1-5. RIGHTS OF GROUNDWATER USERS

Query response to the following SEARs for SSD 5765:

Figure 1: Location of monitoring wells (Jacobs (Australia), 2020)

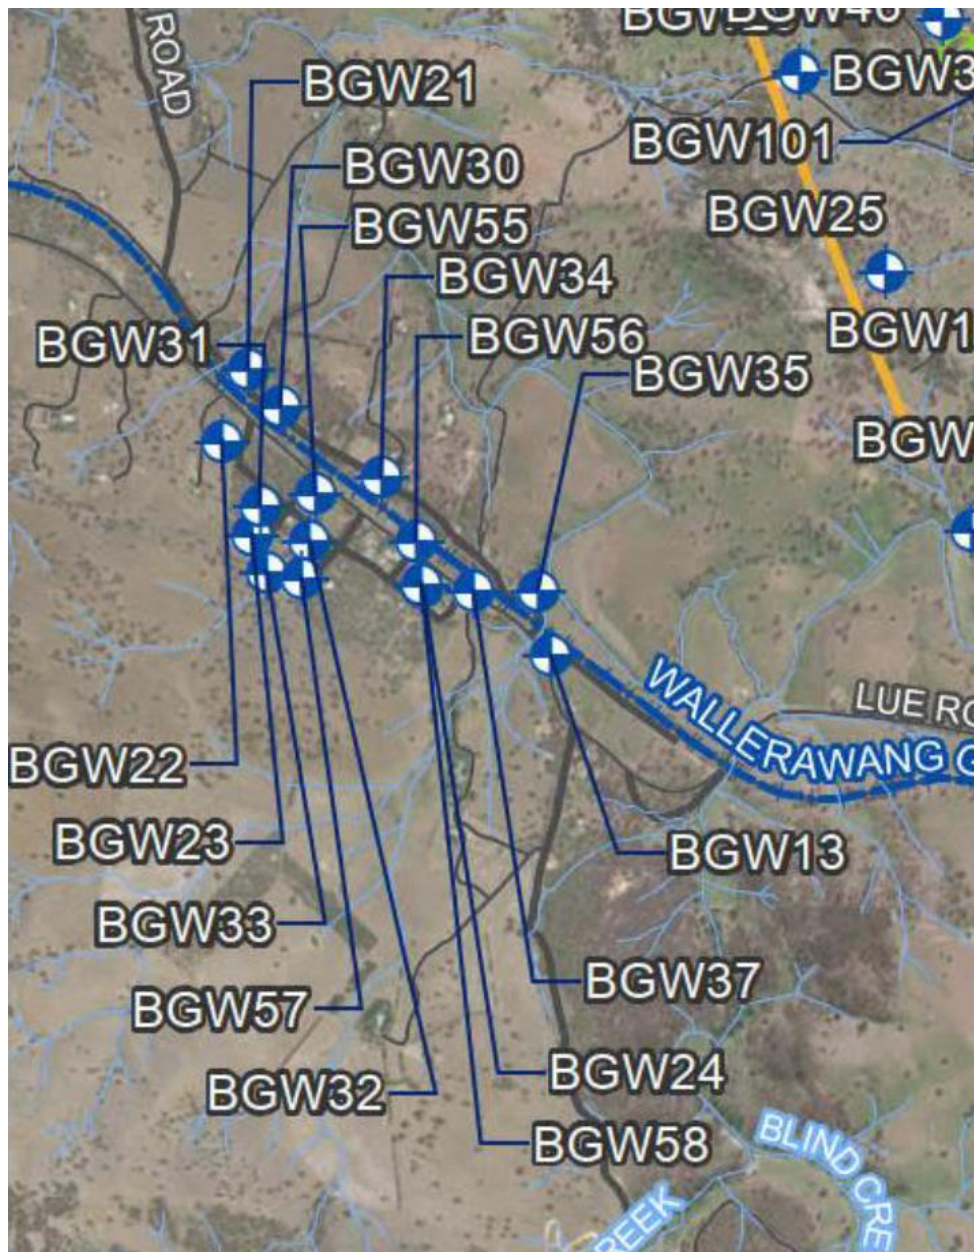
The monitoring bores reported in the EIS located within 1.5 km of Lue are shown in Table 1. The *NSW Aquifer Interference Policy 2012* requires baseline groundwater conditions to be established. It also requires quality impacts from licensed water users of connected groundwater to be established.

Despite conclusions portrayed in Table 22 (Jacobs (Australia), 2020, pp. 5-110), there is no evidence of non-potable water quality in bores in Lue from the sampling undertaken (Table 1).

Table 22 (Jacobs (Australia), 2020, pp. 5-110) indicates the following exceedances for ADWG, however, these appear to be errors requiring explanation as highlighted in Table 1 above:

- BGW21 manganese: 11 samples reported below 0.2 mg/L (average of 0.064 mg/L), well below the 0.5 mg/L ADWG limit. The 12th sample on 01 May 15 reported 31.1 mg/L
 - No comment provided on whether the single 31.1 mg/L reading led to the average being >0.05 mg/L, or whether it is simply an error
 - If the 01 May 15 reading is considered, the mean is 2.650 mg/L not 1.354 mg/L (greater than ADWG) as reported in the EIS
- Average arsenic concentrations for BGW32, 33, 35 and 37 are reported as >0.01 mg/L (above ADWG) in Table 22, however, no individual analyses >0.01 mg/L are reported:
 - BGW32: Arsenic <0.002 mg/L on 09 Jan 14 and 08 April 14
 - BGW33: Arsenic <0.002 mg/L on 09 Jan 14, 08 Jul 14 and 25 Feb 16
 - Similar analyses for BGW35 & 37
